Subject: IOZ Design Review – 22 Bramhall (Maine Medical)
Written by: Caitlin Cameron, Urban Designer
Date of Review: Wednesday, January 17 2018

The projects at 22 Bramhall Street – East Tower and Visitor Garage expansion - were reviewed according to the adopted IOZ IDP and Regulatory Framework standards by Caitlin Cameron, Urban Designer, Jean Fraser, Planner, and Nell Donaldson, Senior Planner.

NORTH ELEVATION

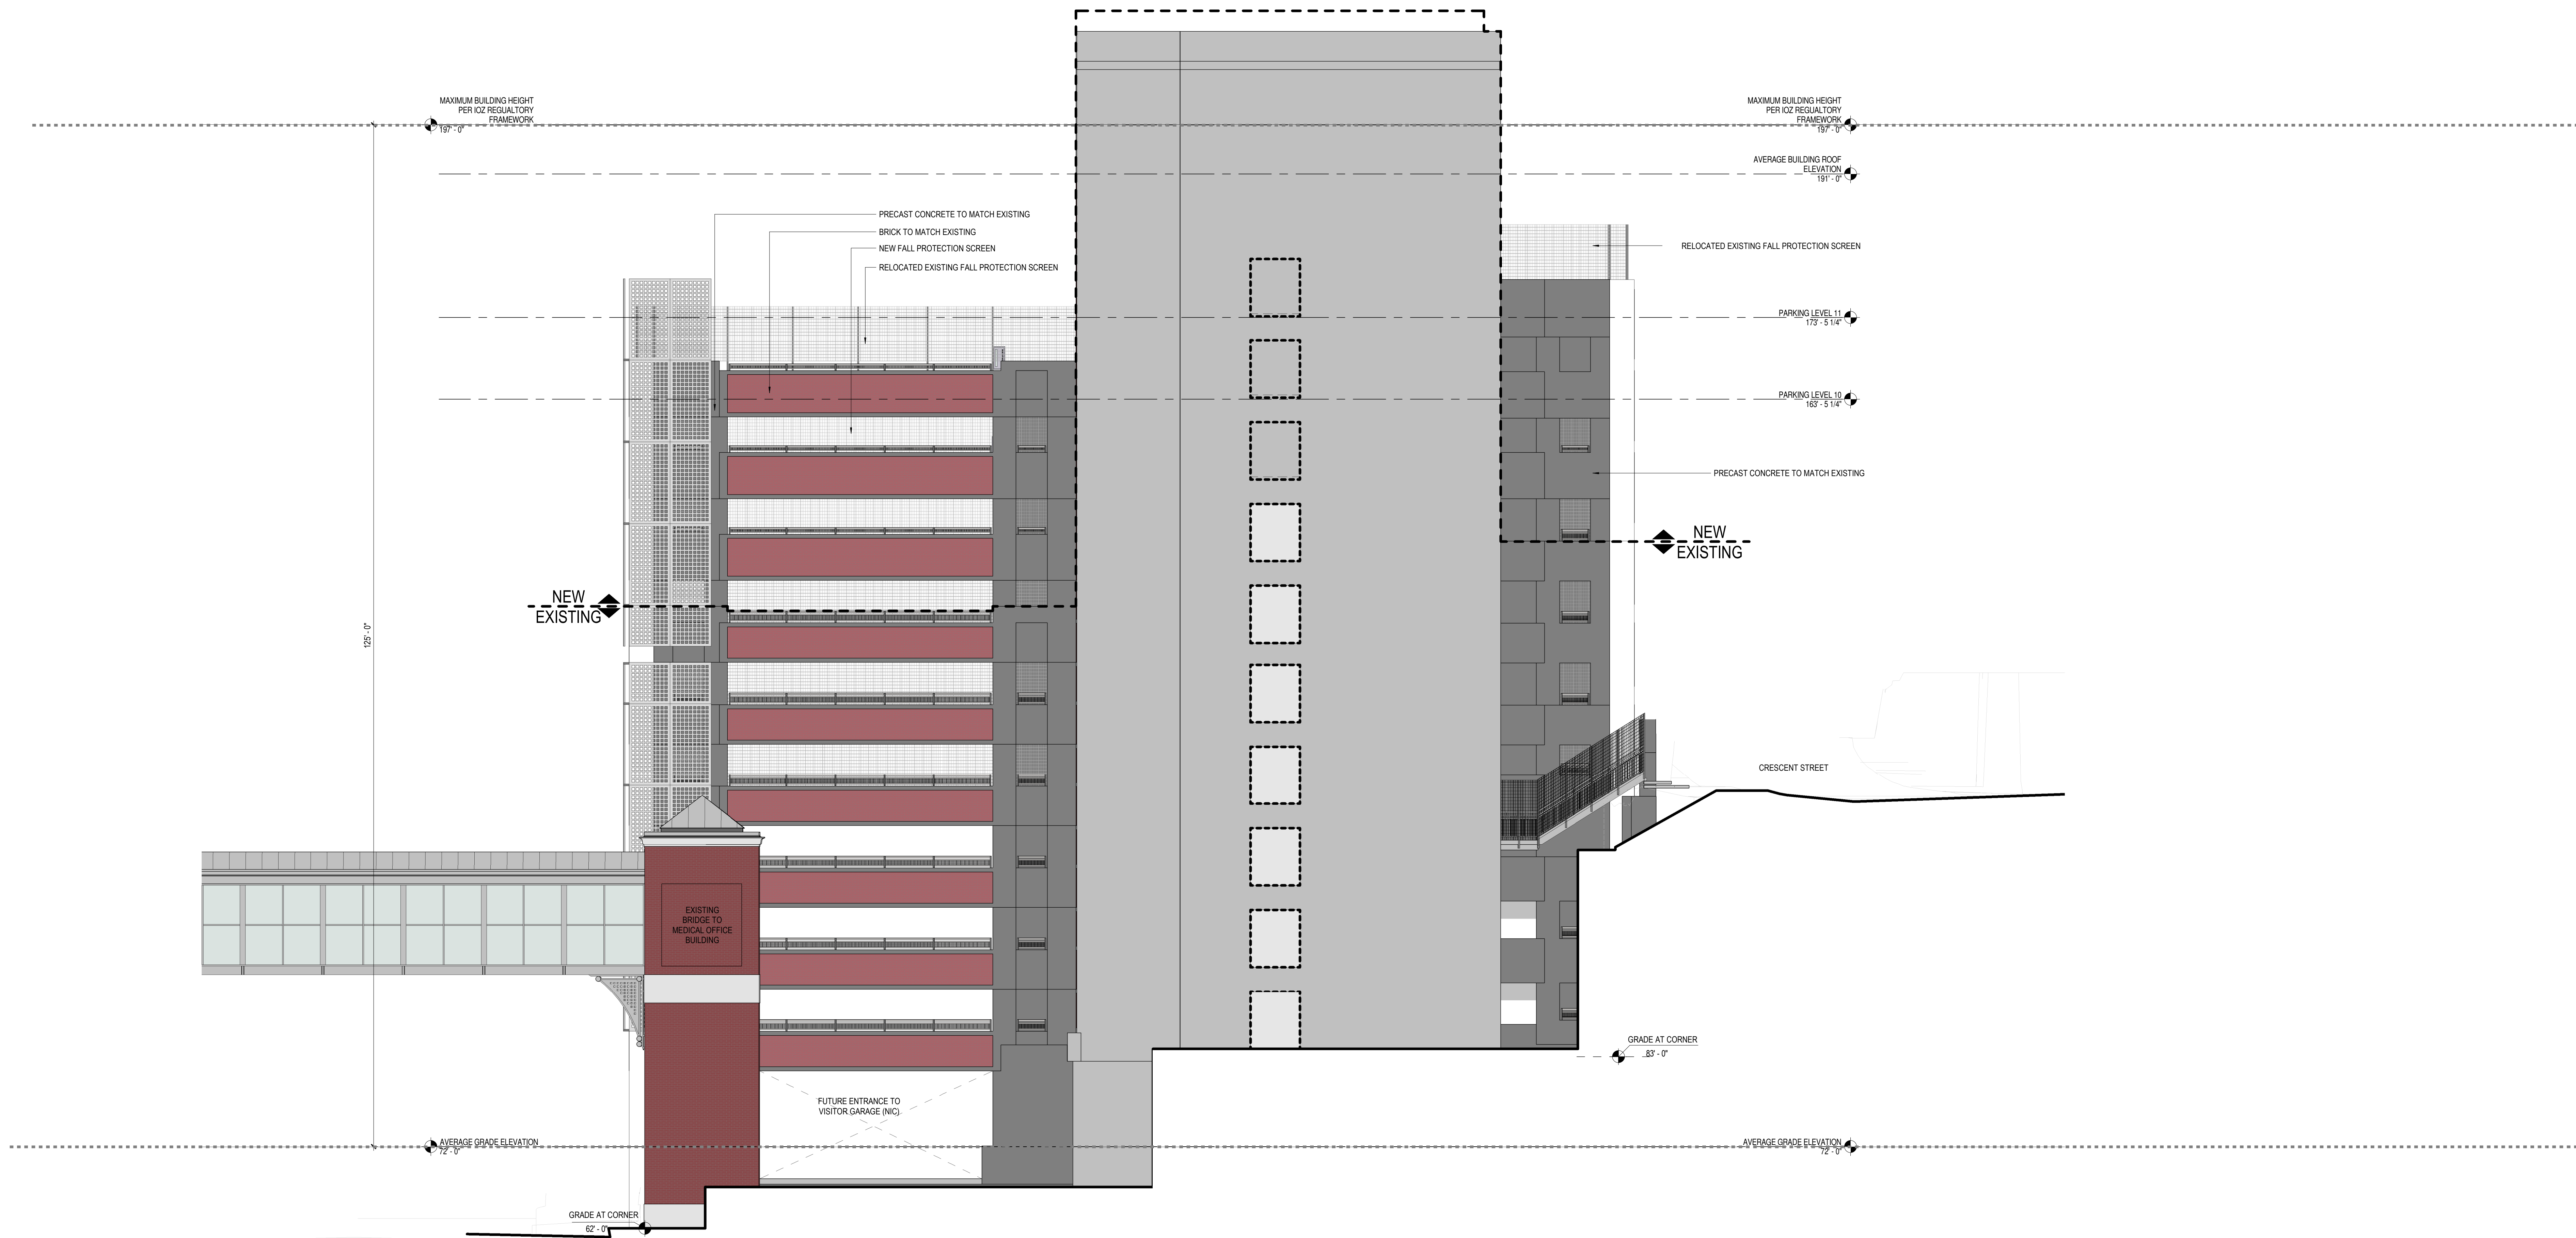
- Please provide a **rendering** showing the visitor garage project in context on Congress Street.
- **More information** is requested regarding materials – label materials on elevations.
- **More information** is requested regarding site lighting.

Visitor Garage: The proposal maintains the existing material palette of brick, concrete, and metal screen. Staff agree this is a logical selection to provide consistency to the building. **However, staff are concerned about the loss of the canopy on the stair tower as an architectural feature.**

Visitor Garage: **Rooftop appurtenances have not been adequately screened or integrated into the building design - this is especially of concern for the long views.**
